2021/1426

Erection of two storey side extension and single storey rear extensions to dwelling and erection of detached garage/garden store (Revised Scheme)(Retrospective)

36 Shepherd Lane, Thurnscoe, Rotherham, S63 0JS

proposed front view.

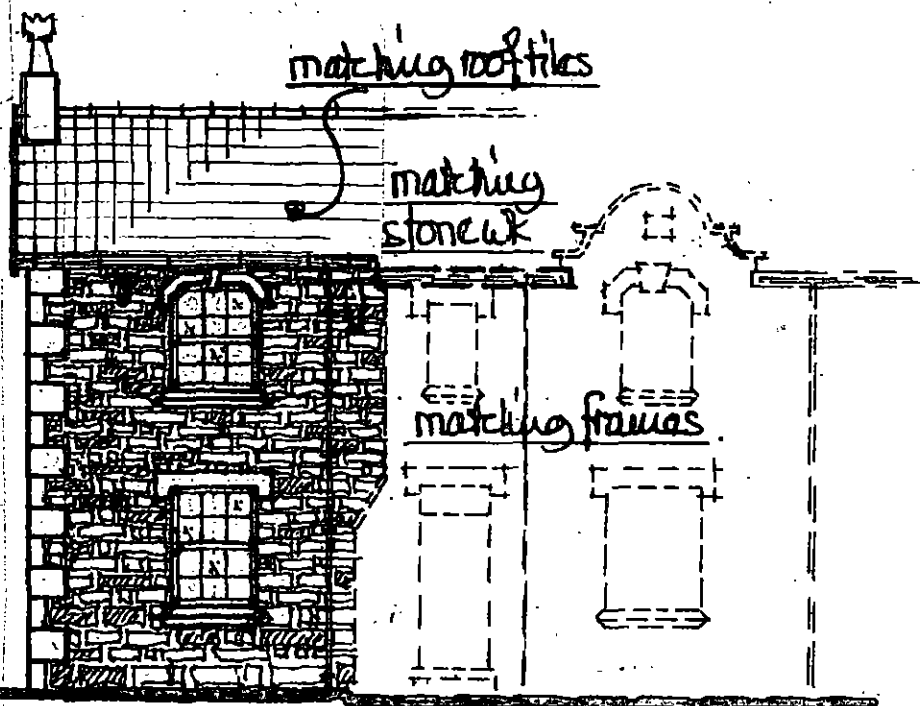
Firstly, the two storey extension has not been built with the set back/set down as per the approved plans. The submitted plans for this current application and the extension as built is not sympathetic to the design of the existing house. The lack of break line within the roof results in an unbalanced dwelling. The decorative eaves have not been replicated and due to the lack of set back and non matching materials, the extension appears overly dominant. The applicant has stated that the lack of set back is a result of allowing the roof/ridge line to follow the existing as it does on the farm cottages directly across the road. Architecturally, these are of a very different style and comparisons cannot be made. This does not remove the fact that the extension was built contrary to the approved plans. The Officer Report for 2019/0646 refers to the design being amended to include the decorative eaves which are a feature of the property. Plans also show the decorative barge board which was Victorian relocated on the new gable or recreated as is following advice from the Conservation Officer.

The applicant has advised that they encountered difficulties in finding suitable reclaimed matching stone which has resulted in the use of new stone. There is a marked difference between the existing dwelling and new extension. Previous planning conditions required the extension to use matching materials which would lessen the visual impact of the extension. At present, the extension appears overly dominant in part as a result of the materials used. The applicant has proposed that the existing property is sandblasted to attempt to match the colour of the stonework to the extension. However, it has also been advised that there is no known timescale to this due to the cost of the work. Consideration has been given to this proposal alongside consideration of how effective an approach might be. However, as by the applicant's own admission, an agreed time period to undertake these works cannot be entered into. Therefore, a condition requiring this to be undertaken within a set period of time could be considered unreasonable.

proposed ground floor plan.

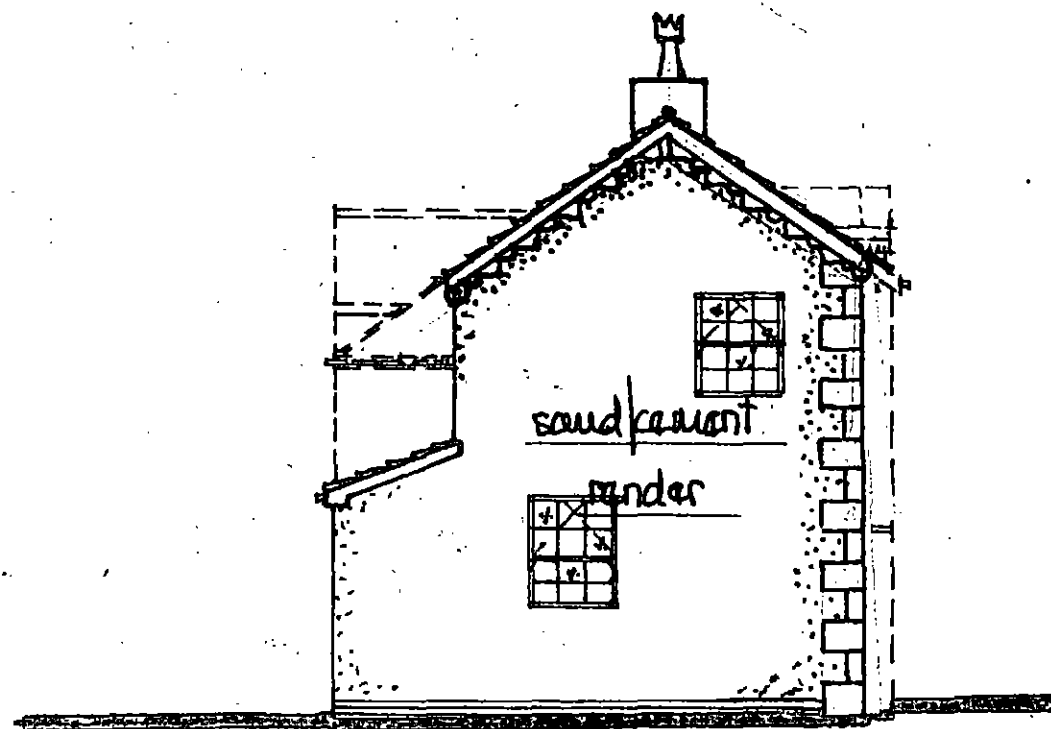
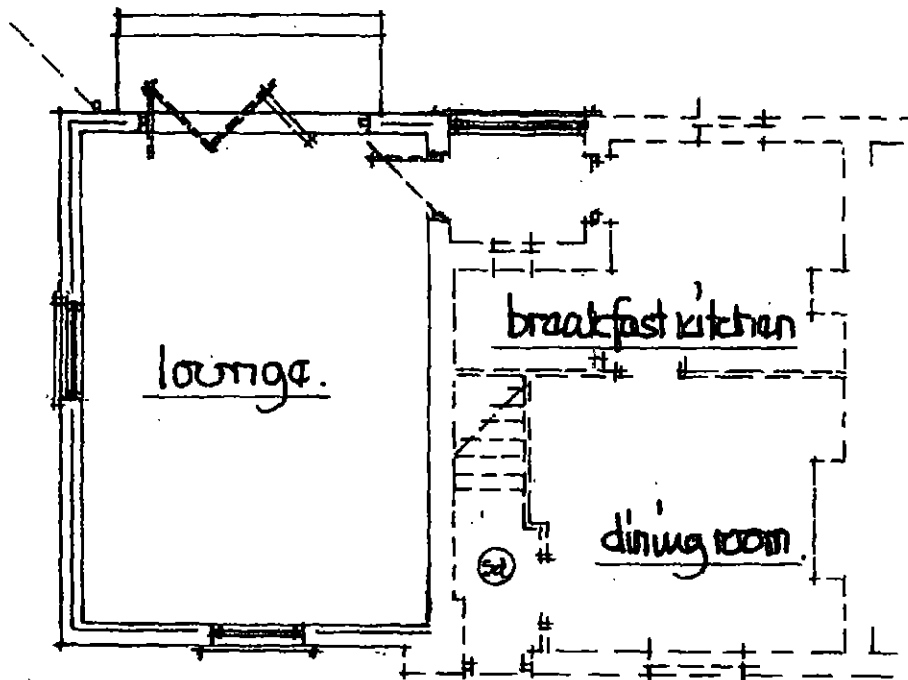
The main issue in terms of residential amenity relates to the creation of a new side window upon the extension. The previously approved 2019/0646 application included two windows to the side elevation of the extension, to be obscure glazed, which was secured by condition. This would negate the overlooking impact that would be created by the extension. However, during the construction of the extension, only one side window was created, in neither of the approved locations and has not been obscurely glazed as per the condition. The extension as built directly overlooks the garden area of the neighbouring property. This could be overcome by changing the glazing in the window to the required glazing, however the applicant appears to be unwilling to do so. The opportunity for overlooking has been reduced as a result of the reduction of windows to the side elevation, however it is still considered that the overlooking is not acceptable. It is not expected that the extension will produce an overbearing or overshadowing impact, being that it is erected on a southern elevation within a large curtilage, but the issue of loss of privacy is a concern.

redrawn dec 19 increased length from approval no 2019/0646.

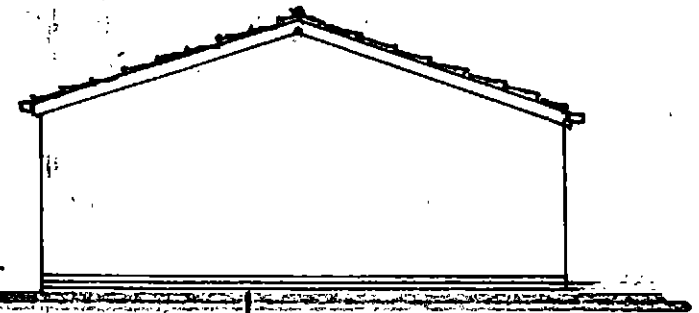
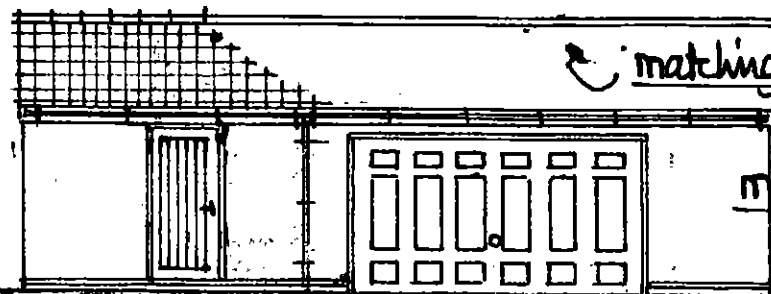
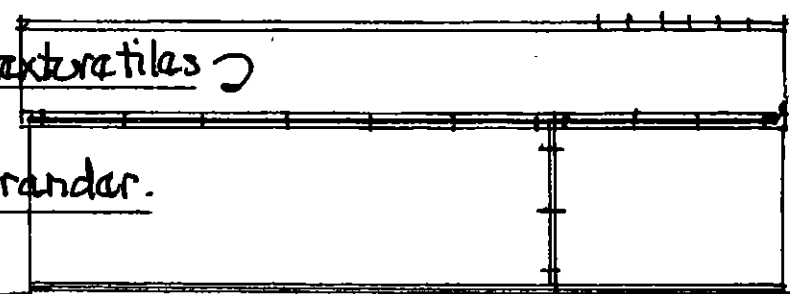
The outbuilding is positioned relatively close to the western and southern boundaries but is not expected to produce a significant overbearing impact. The garage door and entrance door have been built in different positions to the approved plans 2019/1574 and to the plans submitted with this application and at present is stone rather than render. Whilst this does not impact upon its acceptability overall, it demonstrates a wider non conformance to approved plans. Whilst permission has been granted for a garage, the applicant still need to gain a separate consent to cross the public highway to utilise it as such.
